M25 junction 10/A3 Wisley interchange

TR010030

9.32 Applicant's comments on Joint Local Impact Report submitted by Surrey County Council, Guildford Borough Council and Elmbridge Borough Council

January 2020

Figure 3.1 – Widened “Green Element” of Cockcrow Bridge

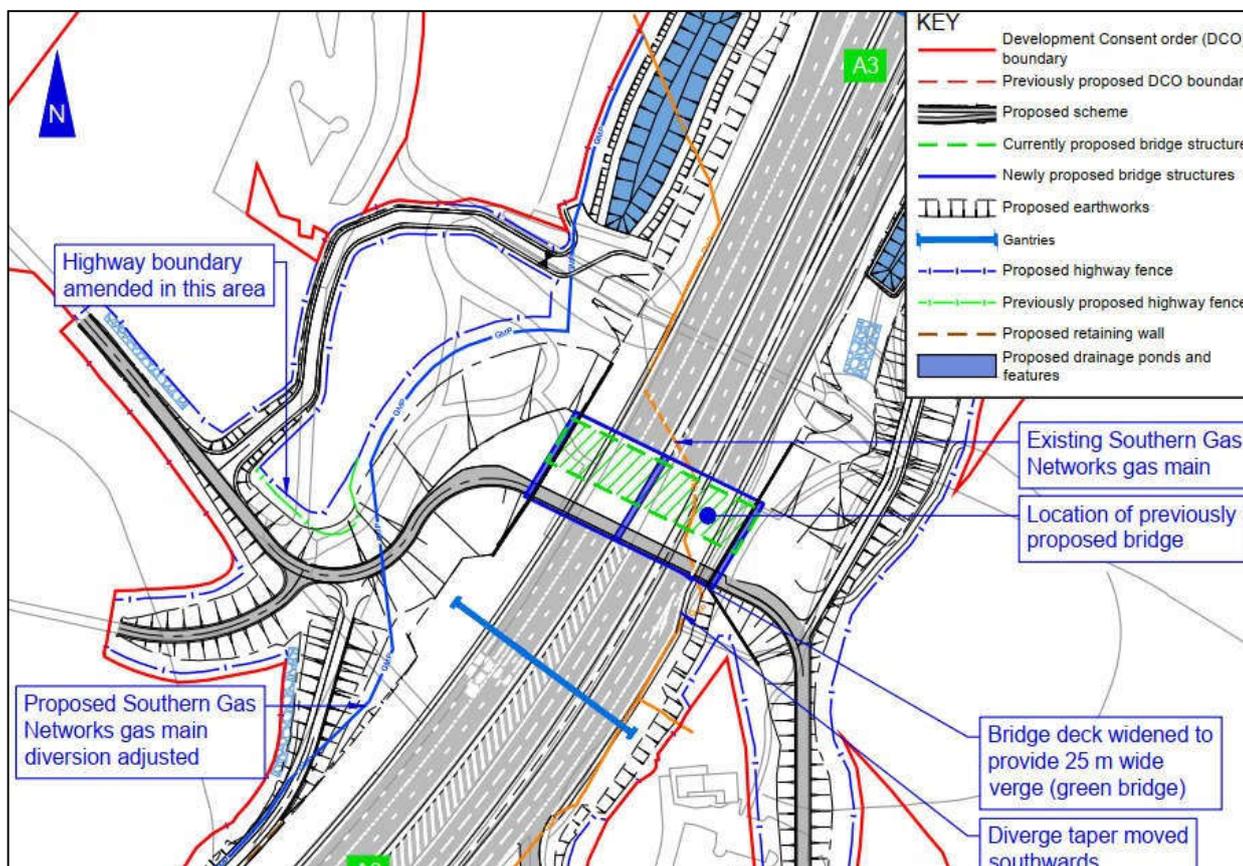
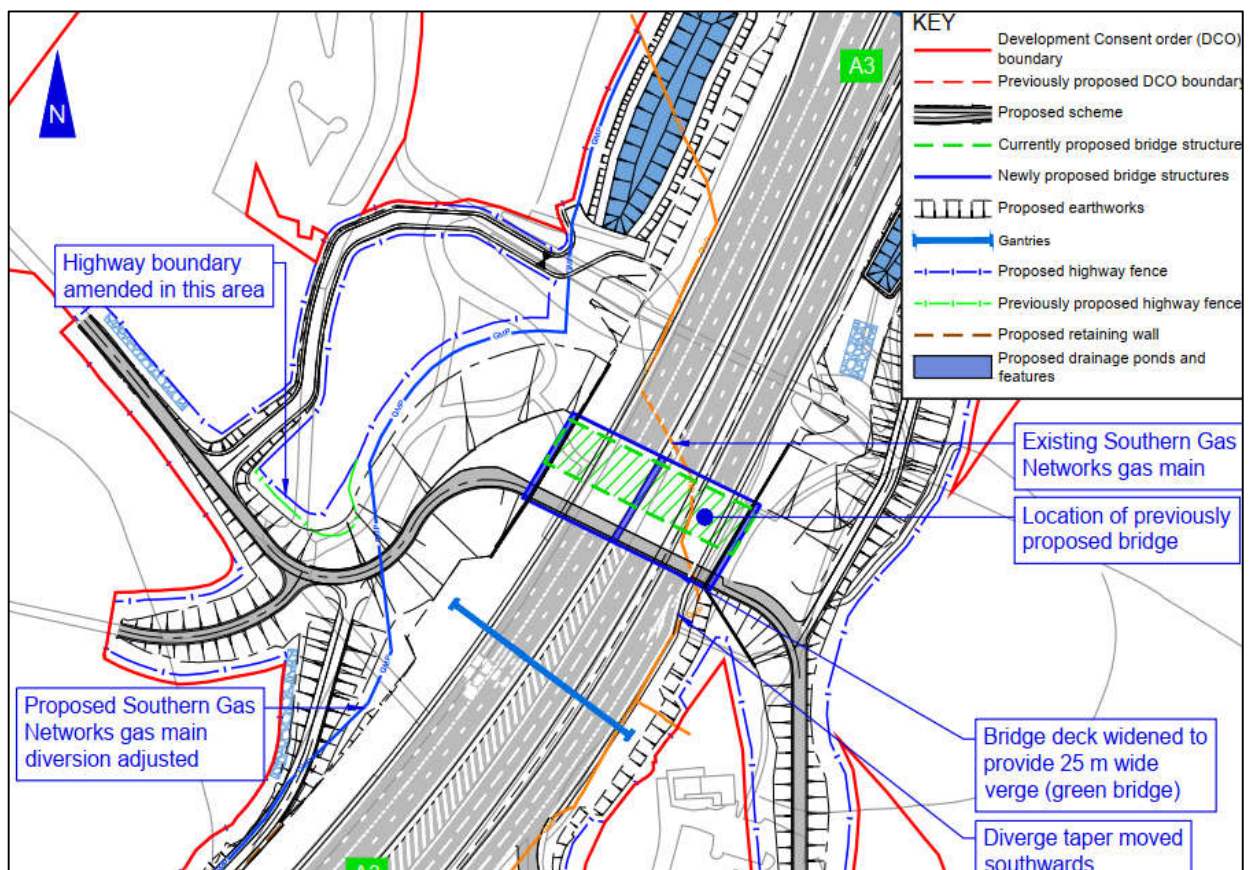
4.4.12	<p>The Green Bridge – The Joint Councils note Change 1 of the proposed DCO changes of November 4th 2019 (AS-023) in respect of the green bridge and welcome the increase in width to 25 metres in order for the bridge to function as a wildlife corridor. The bridge is integral to the scheme in linking the new heathland areas and features in the SPA Management and Monitoring Plan at objective one 'establish and maintain Cockcrow green bridge, providing a wildlife corridor across the new structure which is linked to areas of new habitat creation'. There needs to be detailed monitoring to allow the bridge to prove its ability to link habitats for species and mapping potential connectivity. The Joint Councils ask whether this element is now no longer reliant on funding through Designated Funds. Concerns around maintenance responsibilities for the 'green' element and the associated funding to undertake maintenance remain. SCC consider that if the green bridge is an essential scheme element, maintenance should be dealt within in the same manner as other compensatory mitigation for 'green'/environmental/landscape elements.</p>	<p>The Green Bridge is not required as mitigation for the Scheme's effects but is proposed, subject to securing the necessary designated funds, to address the severance of habitats caused by the existing A3. This is confirmed in paragraph 17.4.4 of the Introduction to the Application and Scheme Description [APP-002].</p> <p>Highways England has also confirmed in its Comments on Written Representations [REP2-014] (see page 42, reference number REP1-020-57) that it will be prepared to accept responsibility for the maintenance of the green verge. Highways England welcomes the local authorities' support for proposals to widen the green verge, again the widened bridge proposal will be subject to securing the necessary designated funds.</p> <p>As to SCC's point on the need for monitoring the efficacy of the green bridge, the SPA Management and Monitoring Plan (see paragraph 7.12.3.4) [AS-015] confirms that monitoring will be undertaken over a period of 10 years and will include measures to assess the vegetation on the green bridge, and utilisation of the green bridge by bats, reptiles, amphibians and invertebrates.</p>
